STRUCTURAL PERMIT CORRECTIONS

November 30, 2022

RE Permit corrections [SUB21-008] for Koneru Residence at 6610 E Mercer Way,
Mercer Island, WA 98040, Permit No. 2112-250

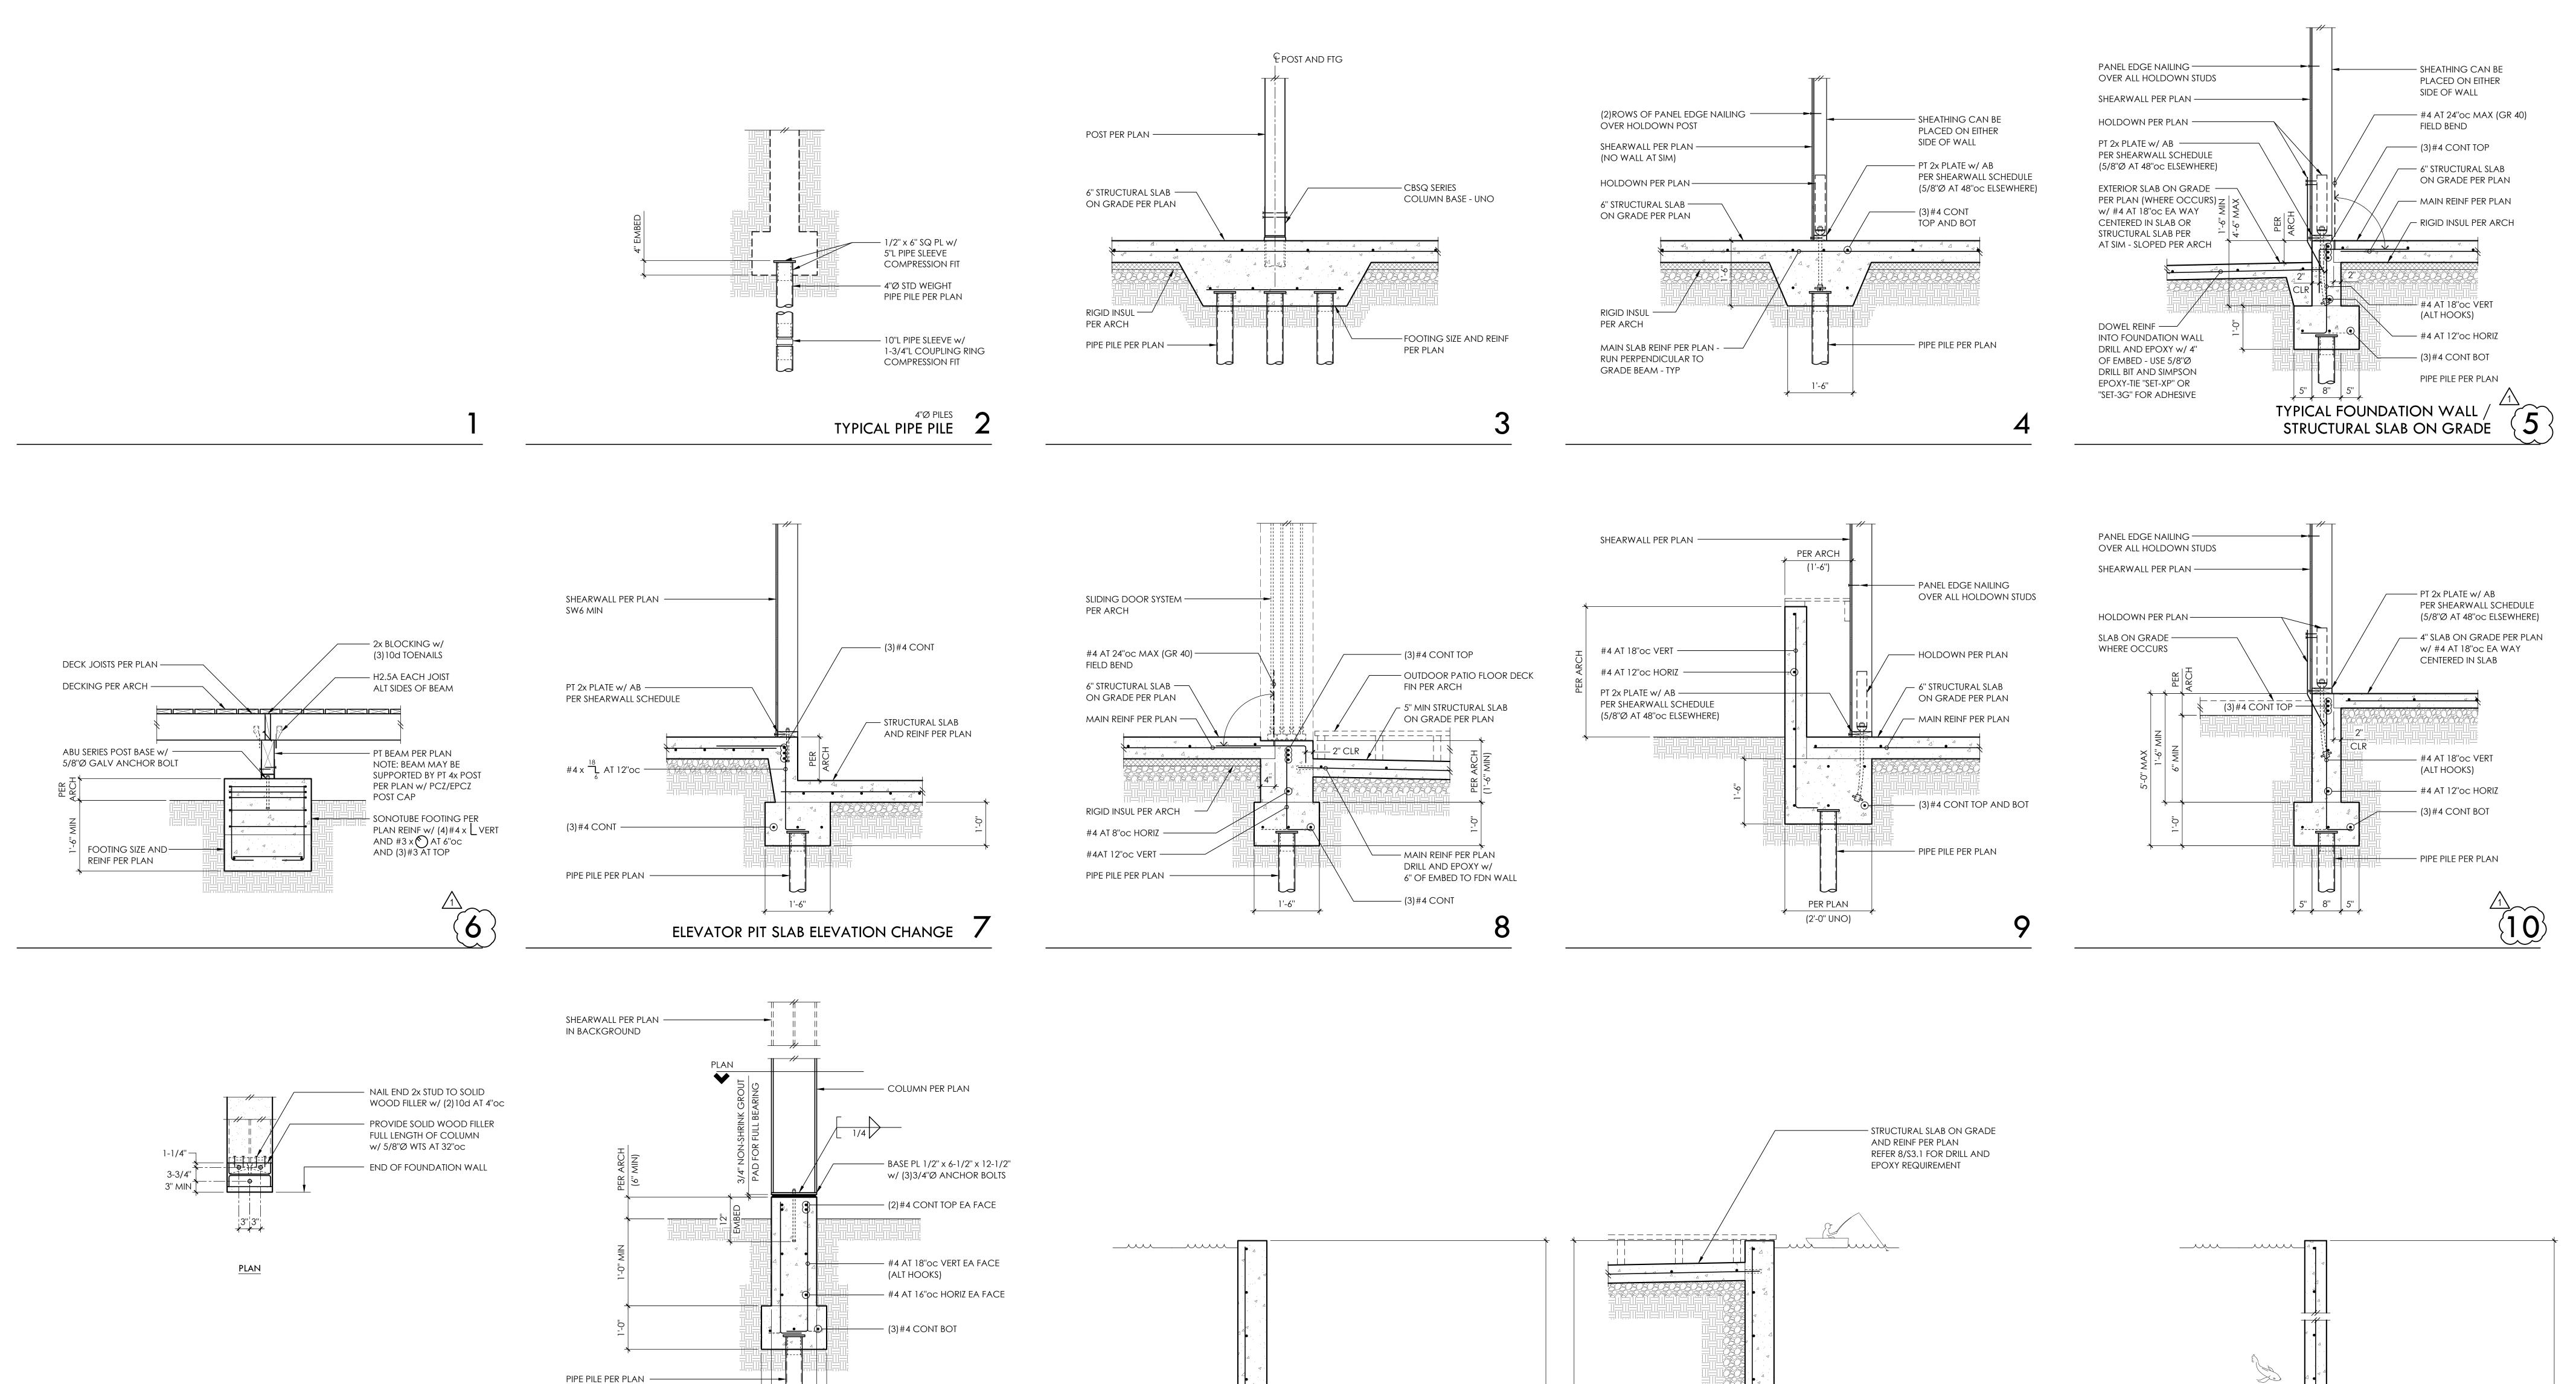
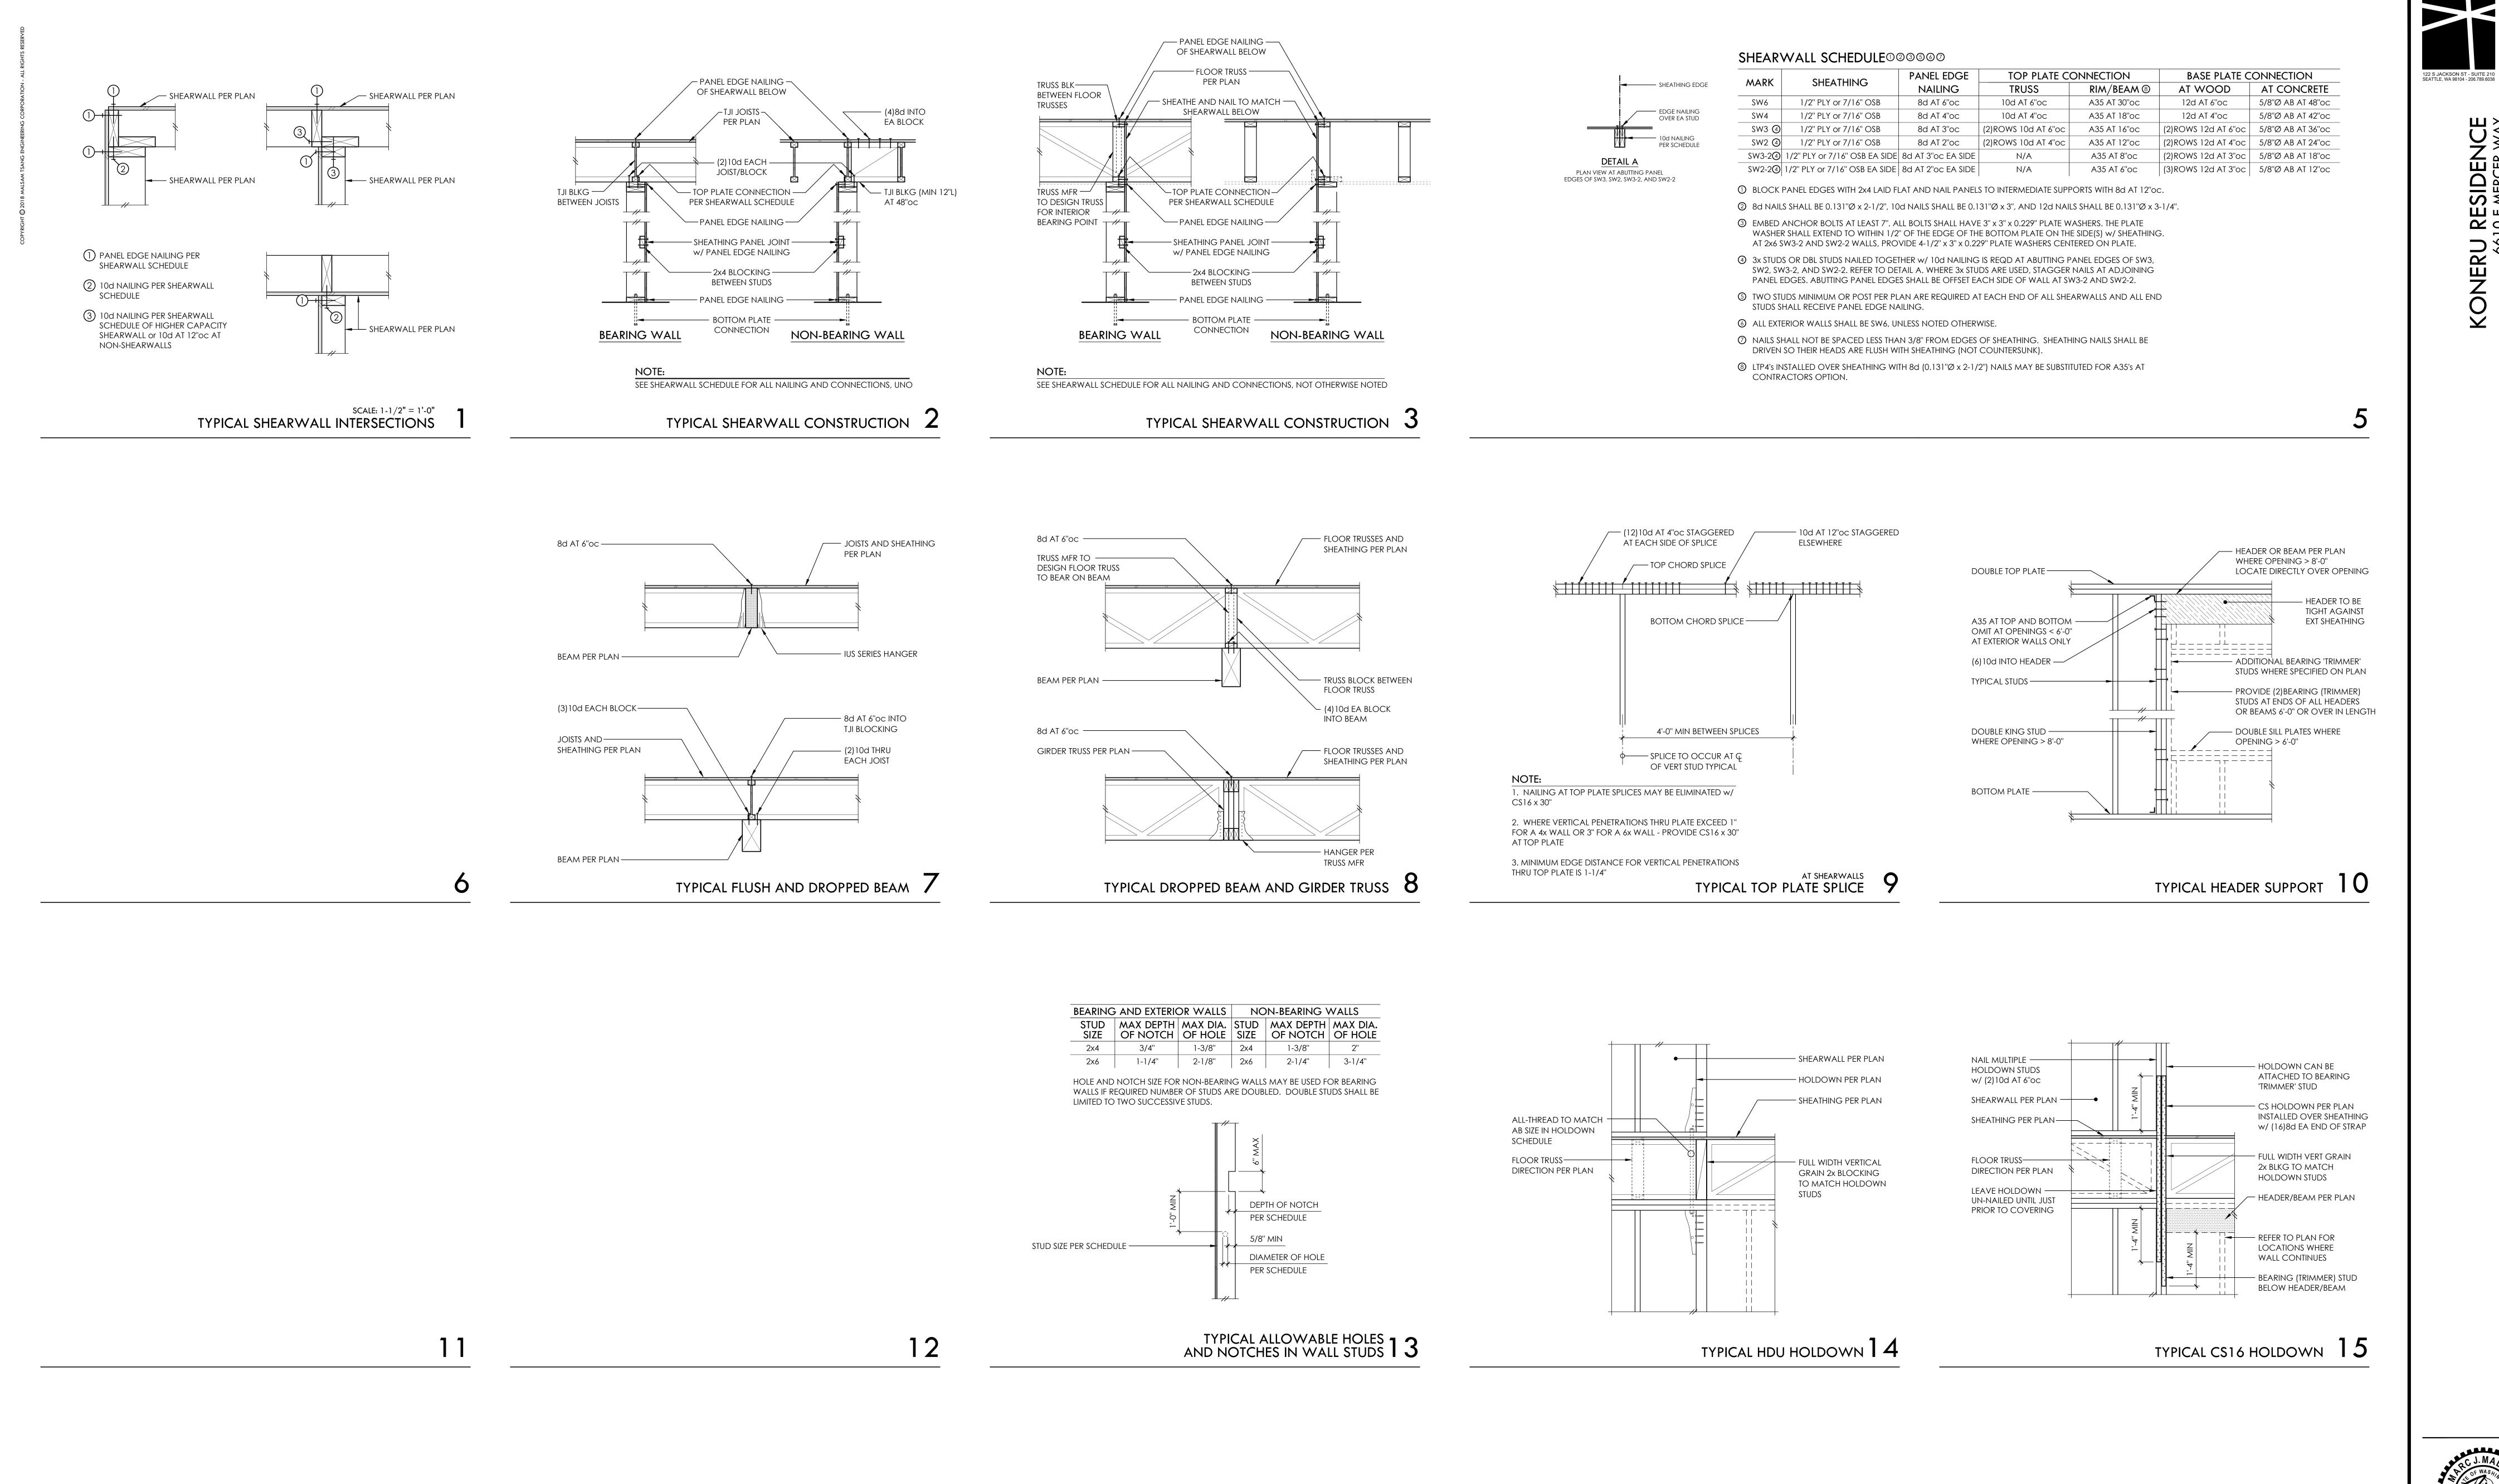
This letter is intended to respond to comments by the City of Mercer Island regarding the structural design as it relates to the potential for collapse of the foundation system during liquefaction and lateral spreading. We have reviewed the June 8, 2021 Geotechnical Engineering Study and the April 12, 2022 Response Letter, both by Geotech Consultants. Based on these documents, we understand that the building site is susceptible to liquefaction during the event of an earthquake. An analysis of the site has further calculated that ground settlement may occur during the Maximum Considered Earthquake (MCE) with a 1-in-2,475-year probability. As a result, the geotechnical reports have recommended that all building structures to be pile supported to mitigate against excessive settlements during an MCE.

We also understand that the potential for lateral spreading is a concern on this site during an MCE. Lateral spreading is an event that occurs with the flow of a liquefied layer of soil toward a free space. As we understand it, the free space in question is Lake Washington. Based on the geography of the site, it is reasonable to assume that this liquefied layer will flow relatively uniformly in the same direction.

For the design of this project, we have interconnected the pipe/pin piles with concrete grade beams and structural slab-on-grade. We believe this reinforced "raft" system consisting of 6-inch diameter extra-strong pipe piles (in lieu of 4-inch diameter standard weight pipe called out on the approved plans) interconnected with concrete grade beams and structural slab-on-grade will perform adequately to support vertical and lateral deformations in a seismic event.

Based on the review of the geotechnical documents, it is our professional opinion that the pile and grade beam system as presented in our structural drawings dated November 3, 2022 can sustain large displacements and provide adequate support of the residence to prevent building collapse.
